WRITTEN REPRESENTATION

East Pye Solar — Planning Inspectorate Reference EN0110014

To: The Examining Authority, The Planning Inspectorate

Submitted by: Mr. Alan Graham & Mrs Julie Graham – Interested Parties

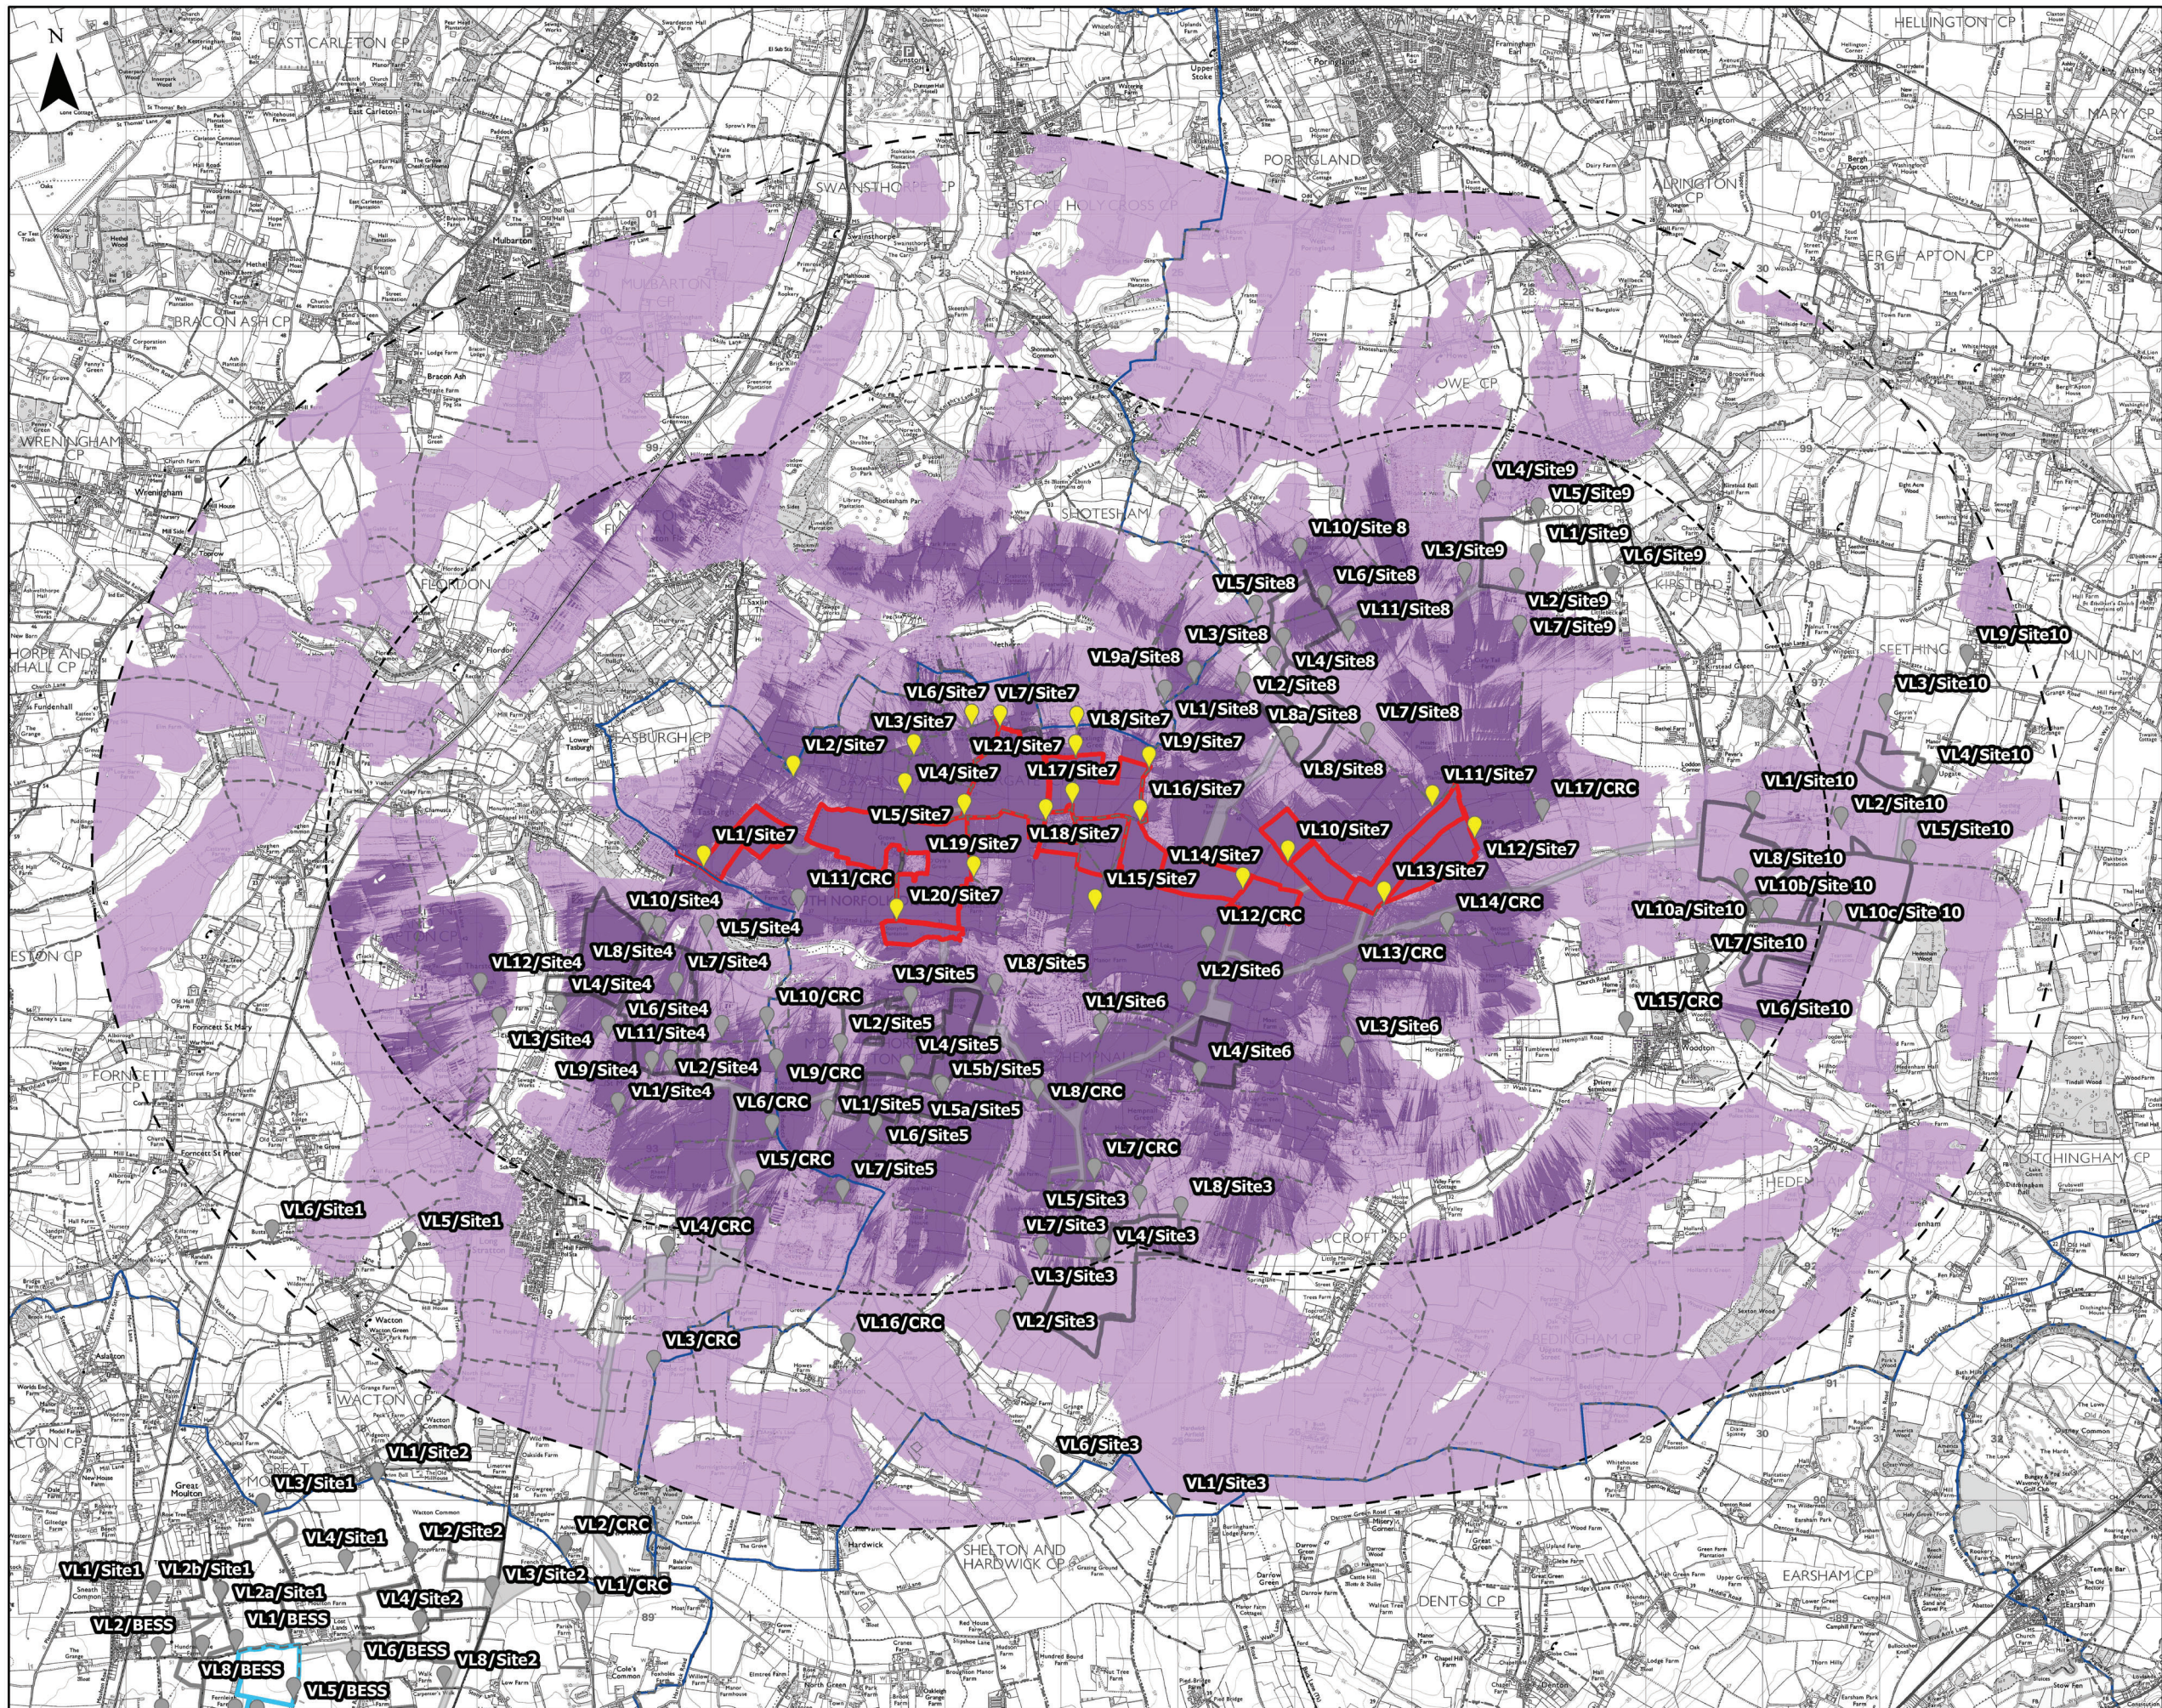
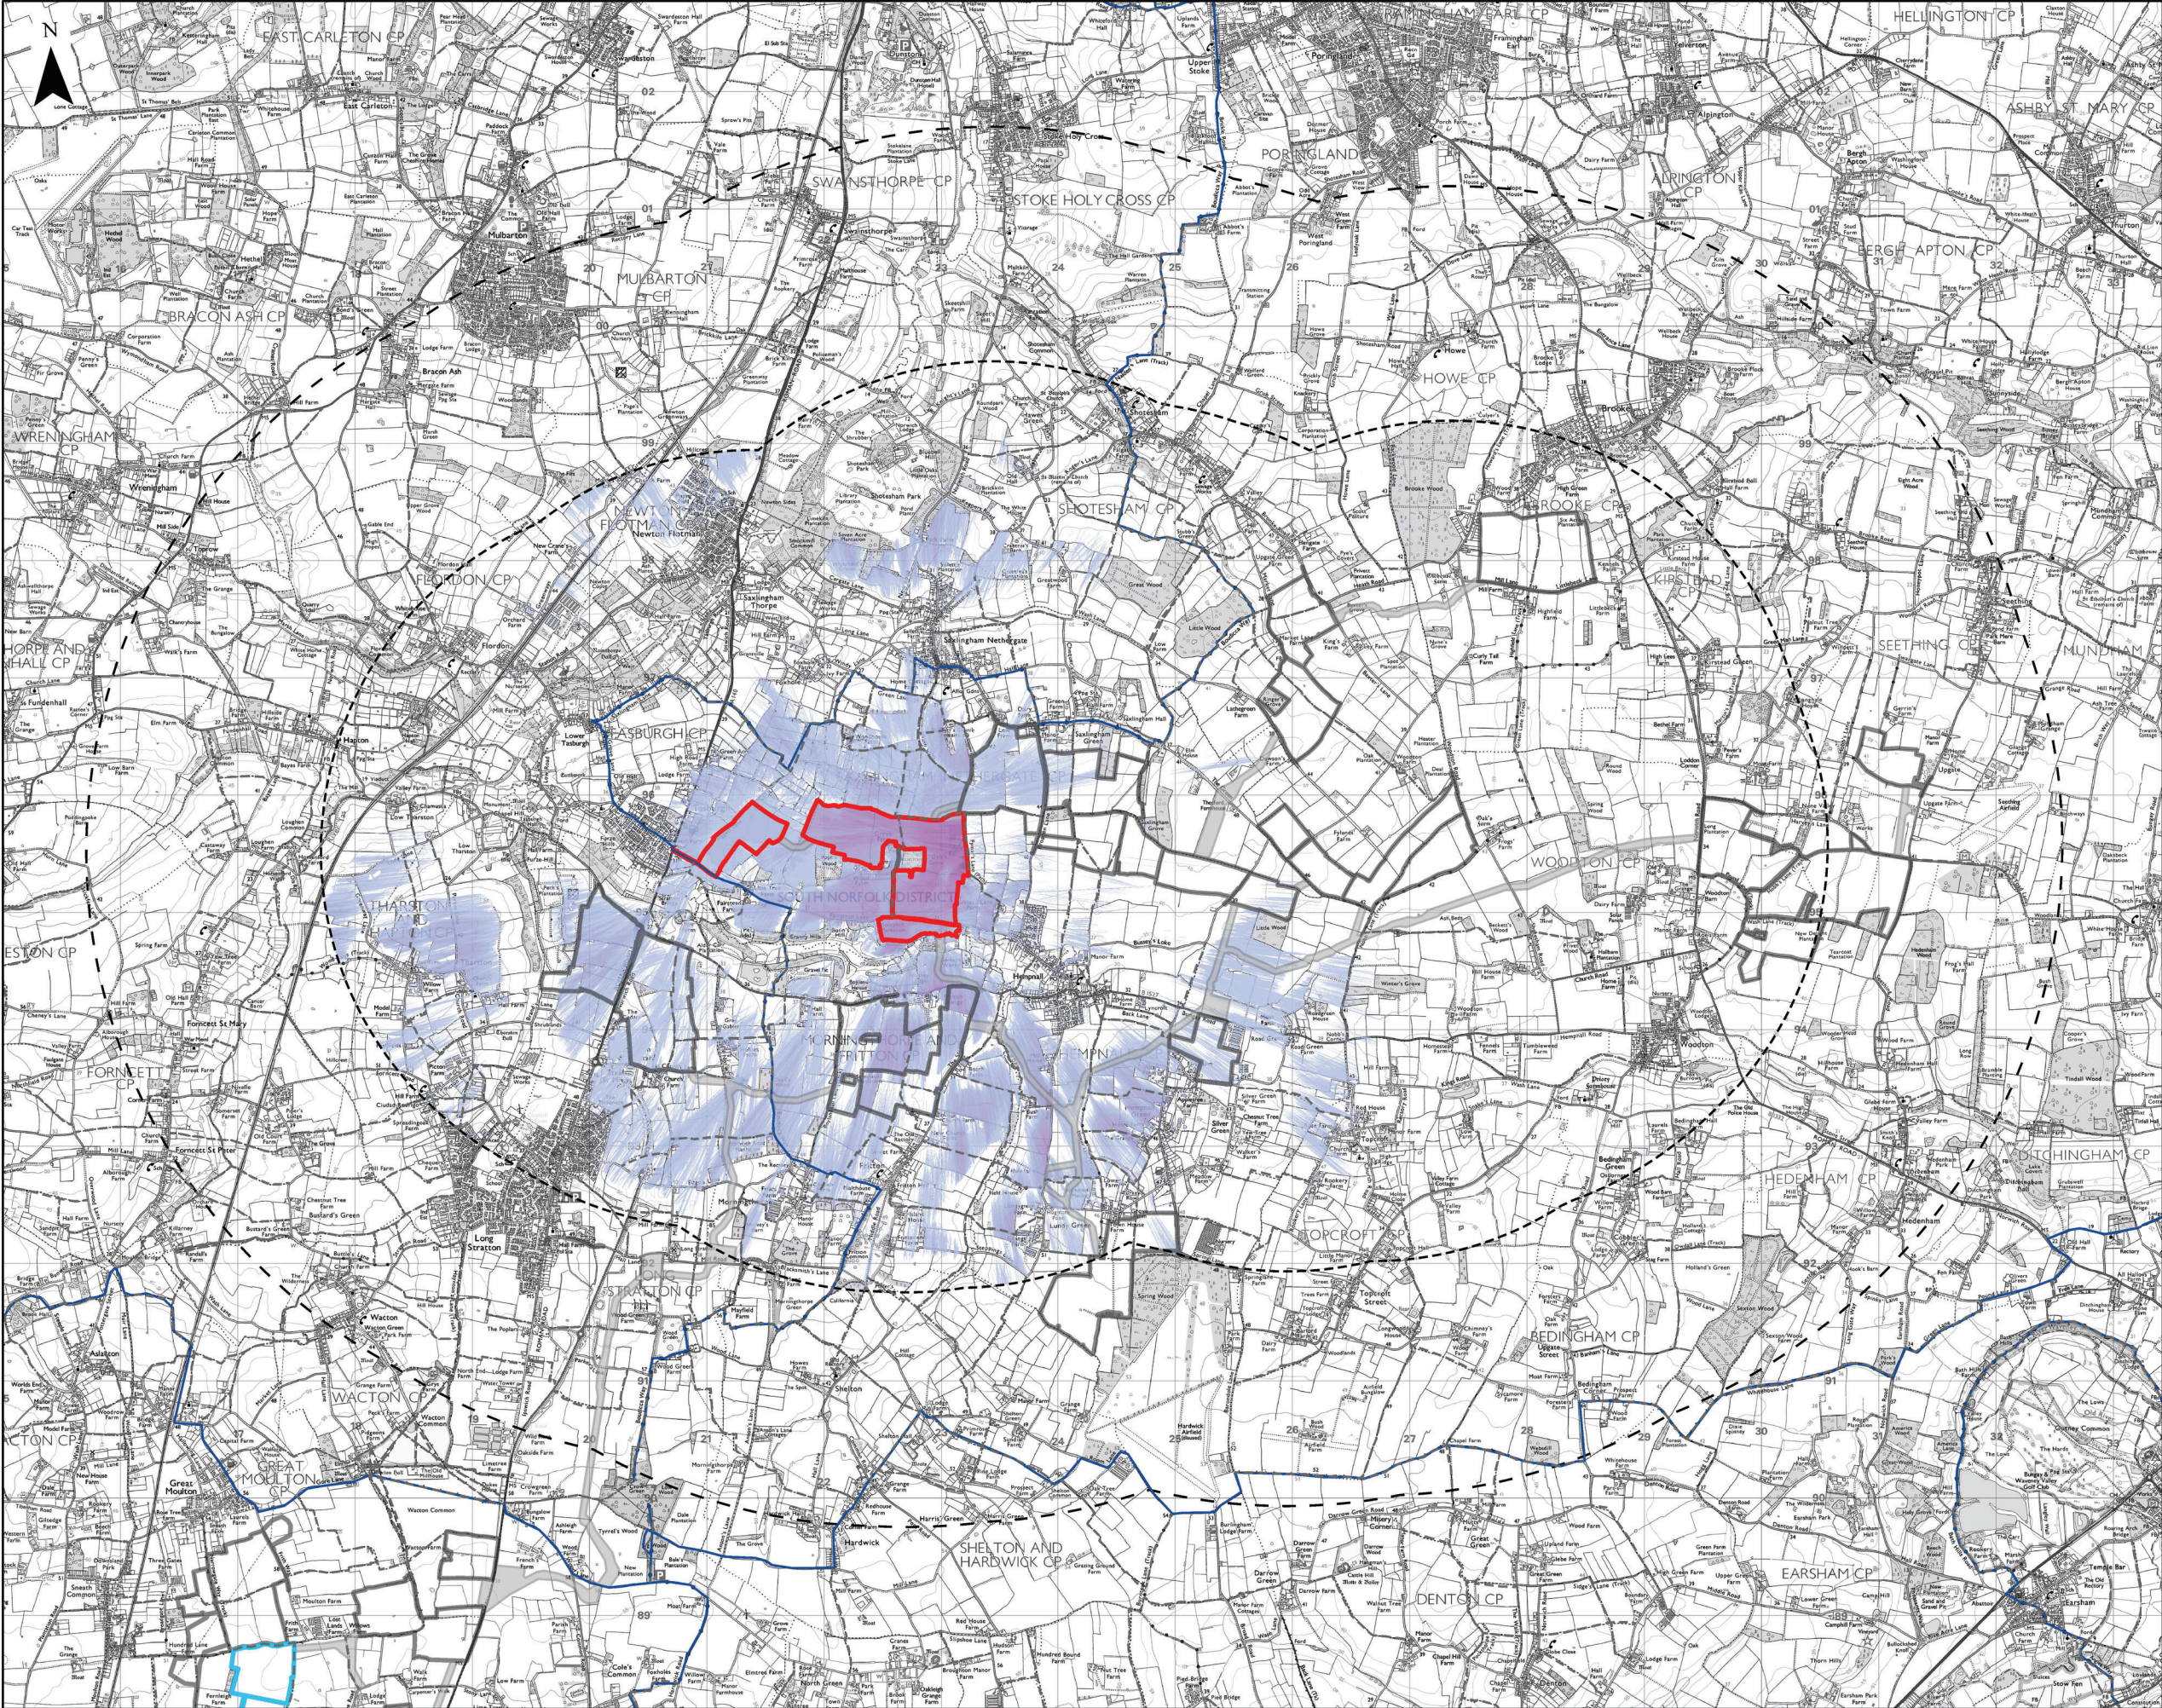
2.12 The Planning Inspectorate's Scoping Opinion (noted in Table 7.1 of ES Chapter 7) specifically directed the Applicant that the ES should assess potential effects on views and visual amenity within the ZTV where significant effects are likely. We request that the Examining Authority requires the Applicant to confirm whether the Property falls within the ZTV for Site 8 (Figure 7.5.4) and Site 7 (Figure 7.5.5) and, if so, to explain why it has not been assessed as a named residential receptor viewpoint.

- (a) Requires the Applicant to confirm whether the Property at Hawes Green falls within the ZTV for Sites 7 (Figure 7.5.5) and 8 (Figure 7.5.4), and if so to explain why it has not been assessed as a named residential receptor viewpoint in the LVIA, given that paragraph 7.5.22 of ES Chapter 7 identifies Shotesham as a settlement from which visual effects are likely;
